# Memorandum

**Re:** Markana Uptown Site Plan Amendment DRB Comment Responses (PR-2018-001284)

This memo outlines the responses and changes made to the site plan for the proposed addition of a 103-space temporary parking lot based on the comments received and reviewed at the December 15, 2021 DRB meeting.

BUILDING FLOOR PLAN - LEVEL P1

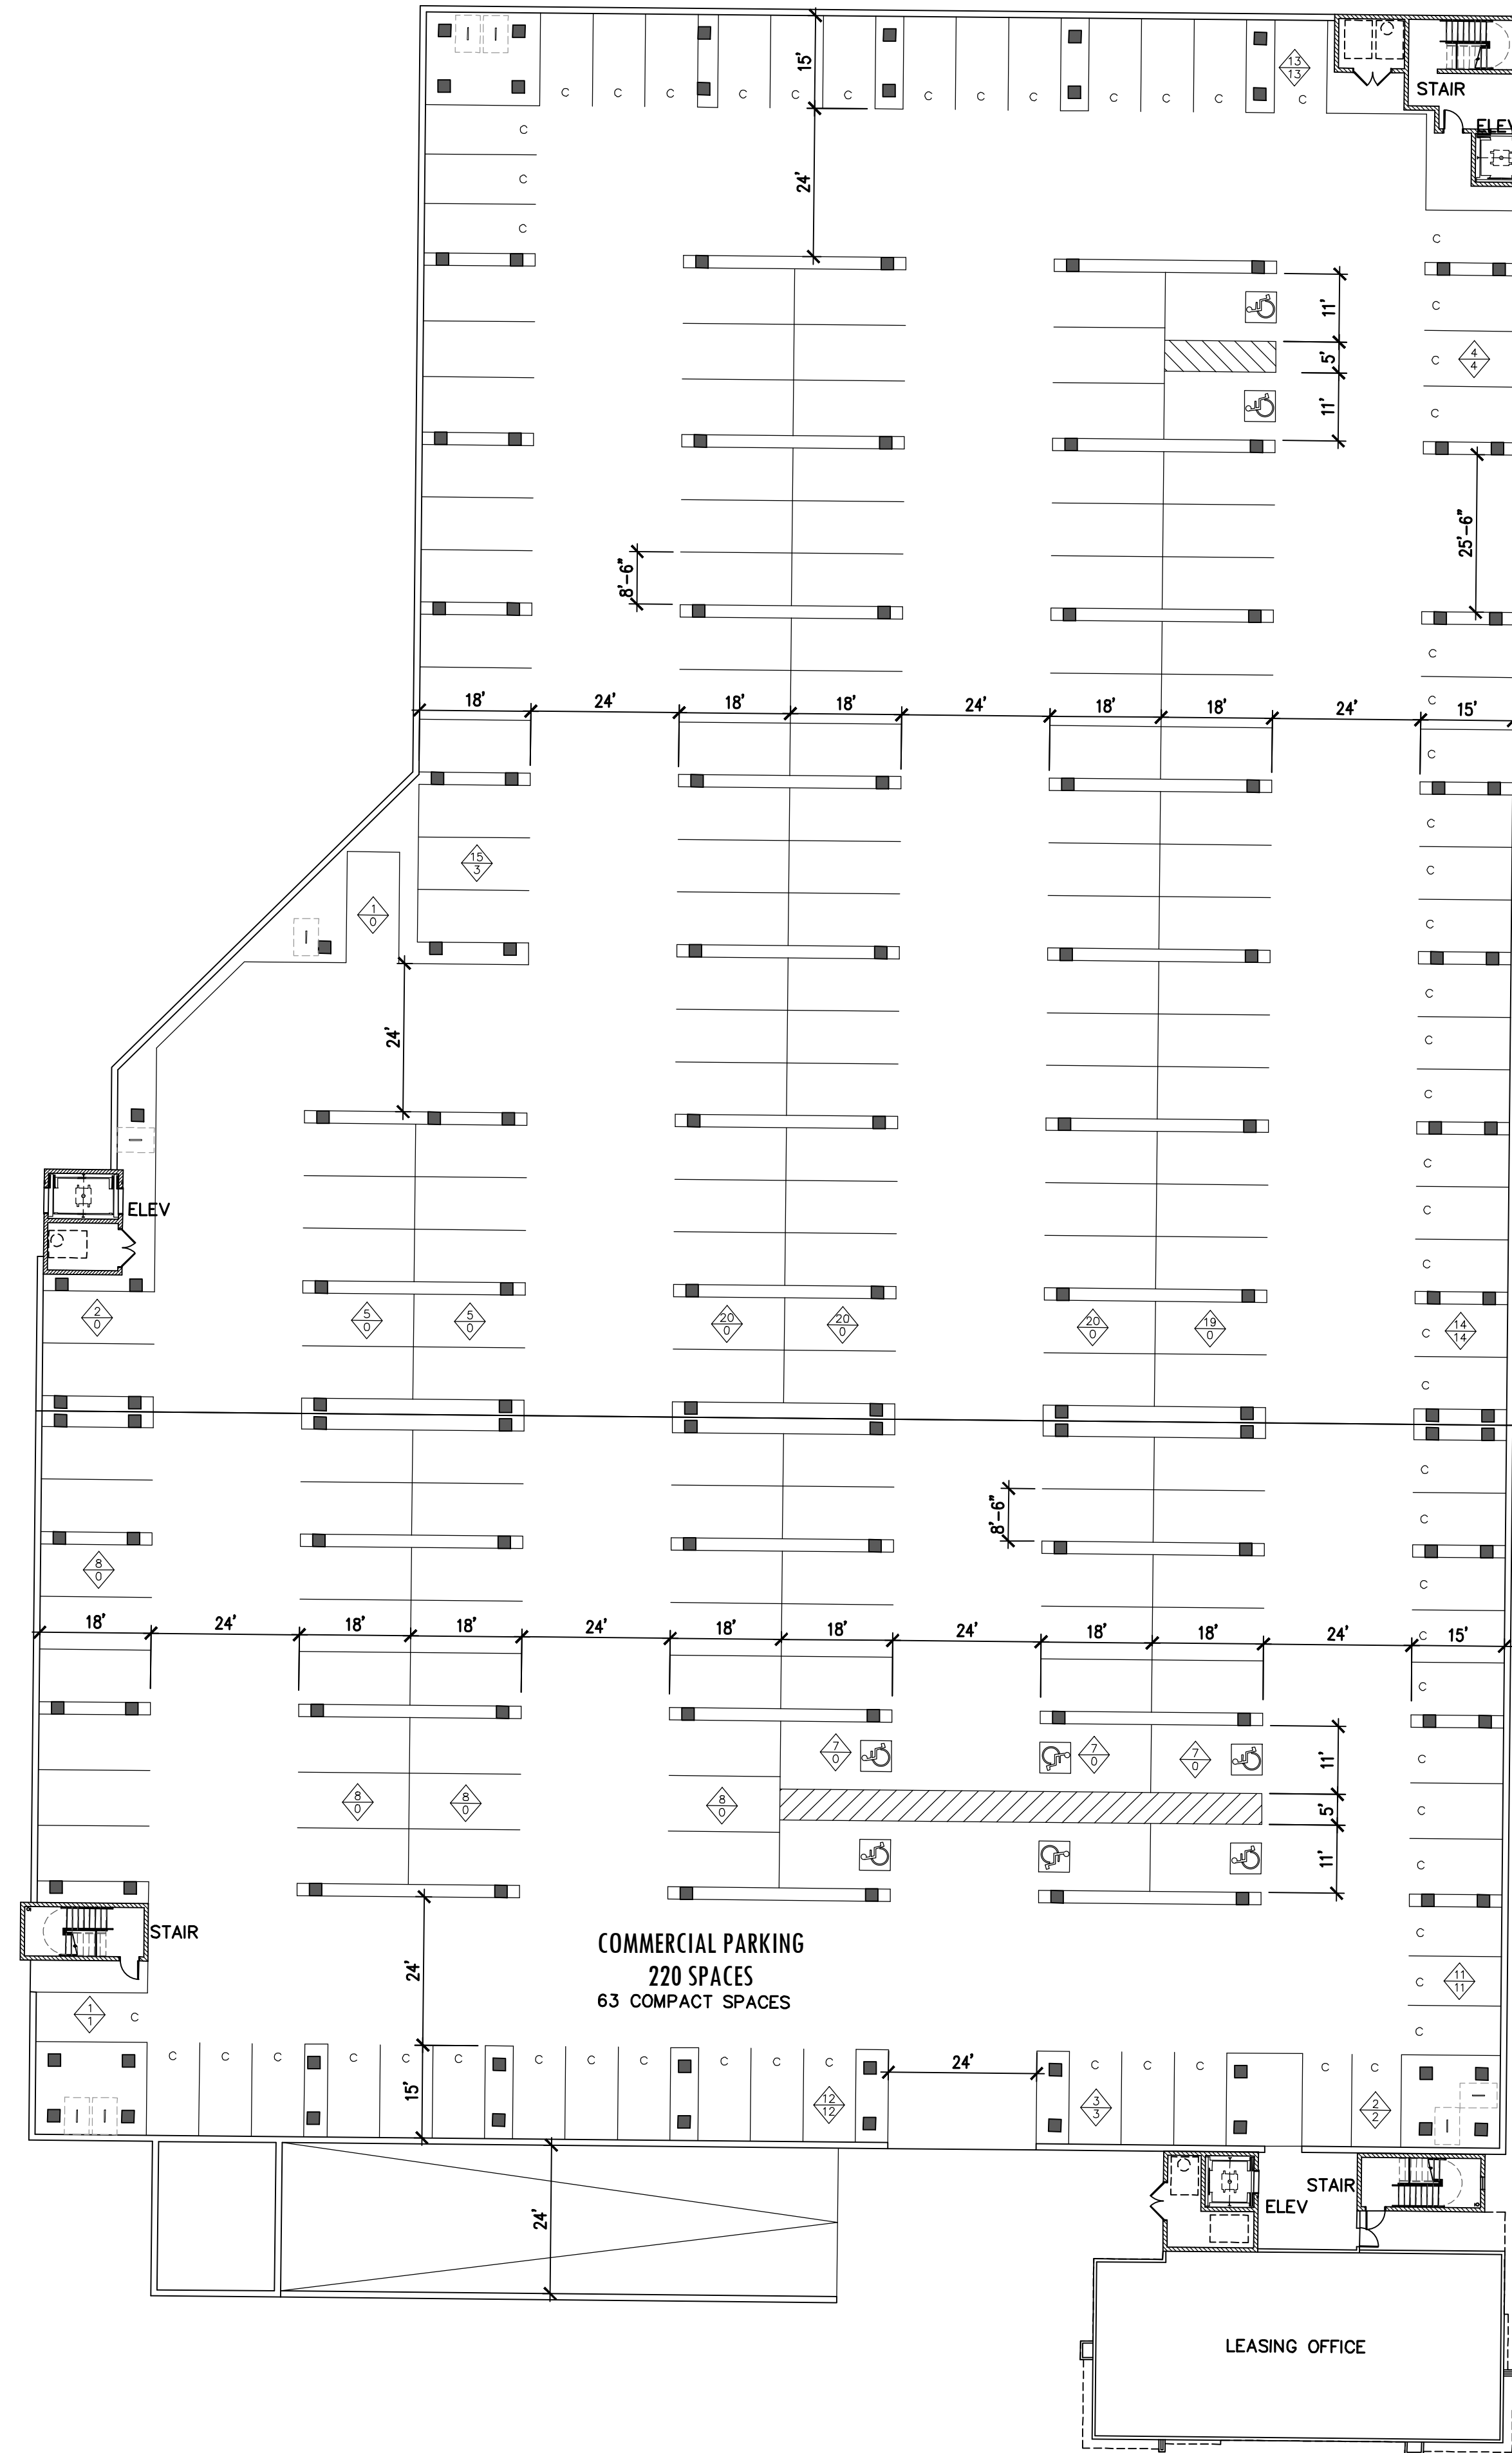
6. Provide existing driveway entrance width for all driveways.
    - *Dimensions have been added for all driveway widths.*
  7. Provide all parking calculations, including those for ADA parking. It seems that the number of ADA parking spaces provided is less than what is required. Please revise the site plan VS building floor plan P1 as necessary. (sheet A3. 11)

- *The temporary parking has been added to the provided parking totals. ADA space locations throughout the site have been clarified with the current parking structure floor plans to show compliance with the requirements.*
